Planning Application Ref: AW/361/21/TC

Location: Craig Rock, 21 Craigweil Manor, Bognor Regis, PO21 4DJ

Description of works: Fell 1no. *Cupressus macrocarpa* (T1) within the Craigweil House, Aldwick Conservation area

TREE LOCATION PLAN.

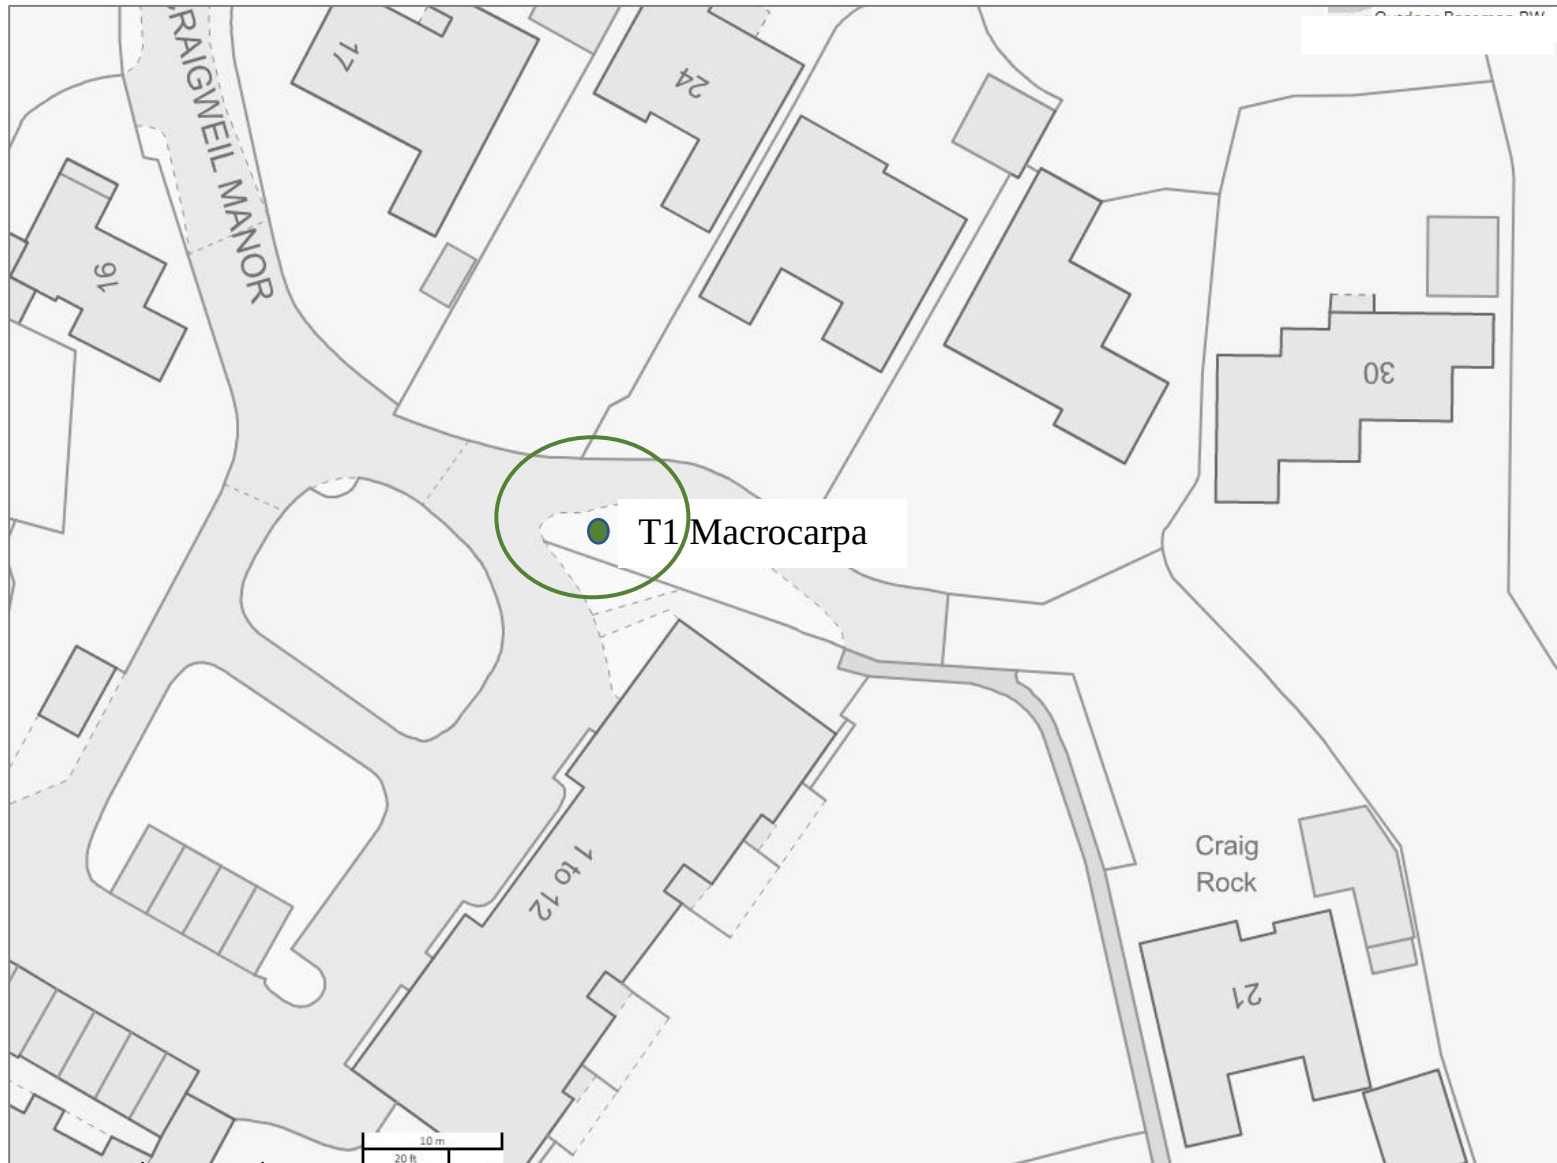
- This tree appears to be in a fine physiological state with a largely unmodified and until recently - a full and attractive crown profile. It is in a prominent position and has obvious landscape value.
- The southern aspect of the crown has recently suffered extensive damage from a violent squall. Several main limbs have been left torn and/or truncated, with most of the damaged material removed from site. Minor branch damage in the upper crown persists and this may have occurred subsequently.
- The crown interior is now exposed to prevailing wind and further damage inevitable. Cypress do not produce growth from dormant buds and so recovery of form is not possible.

- Although the tree is not obviously dangerous following recent gale damage and may still provide some visual amenity and interest; it is probably not viable for long-term retention as an attractive feature tree.
- I raise **No Objection** to the works that have been applied for and see no reason to make a Tree Preservation Order in this instance.
